CONSERVATION CONSULTATION RESPONSE

Application No: 23/00862/FUL

Address: Flat Above 6 Church Green West Redditch Worcestershire

Proposal: Construction of new first and second floor rear extension, conversion of existing offices and existing apartment into 4 new apartments comprising 2 no 1 bedroom units and 2 no. 2 bedroom units

WILLIAM STREET ELEVATION

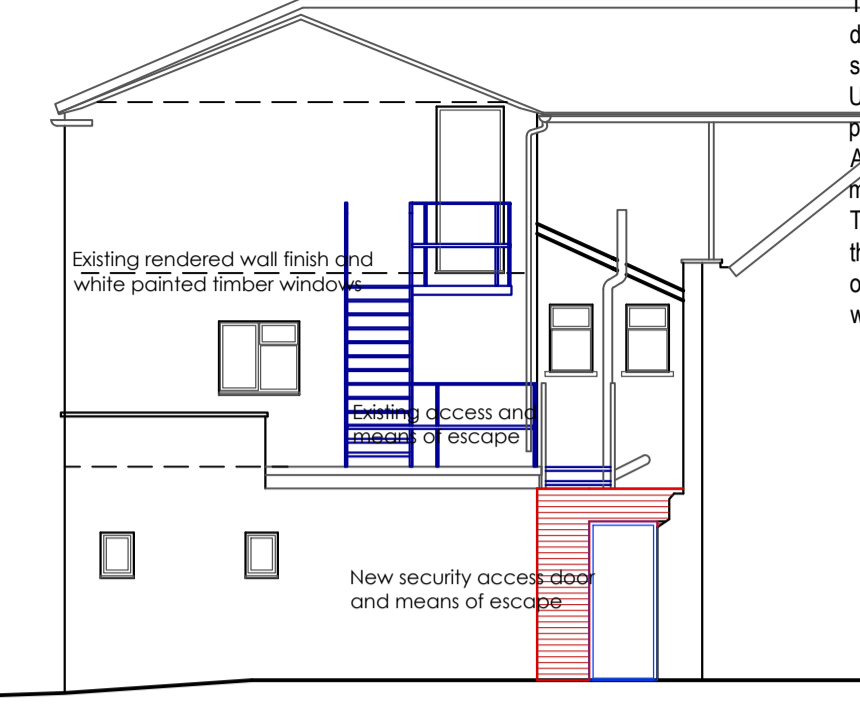
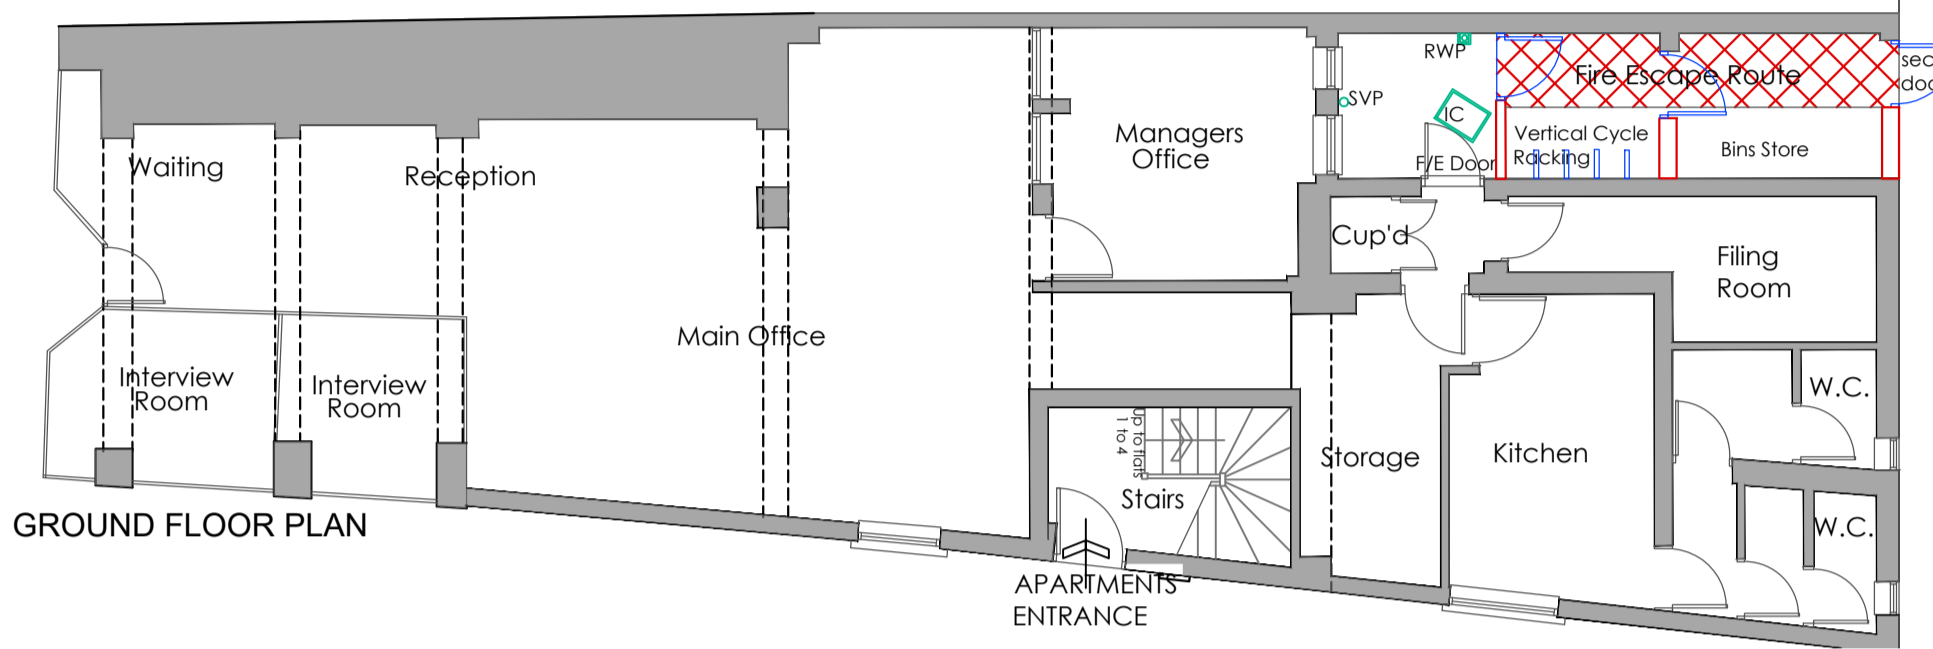
When viewing the rear of the buildings from William Street, there is an organic and undulating roof line which clearly shows the historic street pattern and buildings contributing to the Conservation Area. The two-storey extension would be a bulky addition to the roof line, and would impose upon the neighbouring properties in the near vicinity, detracting from the significance of the CA, and eroding its historic patterns. It is acknowledged that there are some modern extensions to the rear around the car park, but these are not positive additions and should not be used as an example of good development.

There is currently a character on William Street of buildings which step down in height from Church Green West along William Street. This may or may not have been the historic character, but it is the current character, and that character contributes to the enhancement of views towards St Stephens church. It is argued that an infilling of space here, or an increase of height above the single storey element would "resolve" the west end of the property. However this has not been proved as the current design, by way of its scale and massing, would fail to do this and would instead be a negative alteration in the setting of the Listed Building.

The ground floor extension is C20 and not architecturally appealing, therefore it contributes little to the significance of the NDHA, CA, or setting of the Listed Building. The principal of building on top of this section therefore is not objected to. However, the design of the extension should be addressed. Whilst the diminishing scale of buildings might not be an historic factor, it is a factor that aids appreciation of the Listed Building and allows the historic form of the original part of the NDHA to be read. Therefore, the opinion is shared with the previous conservation officer that a diminished scale of extension in this area would benefit the preservation and enhancement of the views towards the church, therefore preserving and enhancing the significance of the church itself, the character and appearance of the Conservation Area, and the significance of the NDHA.
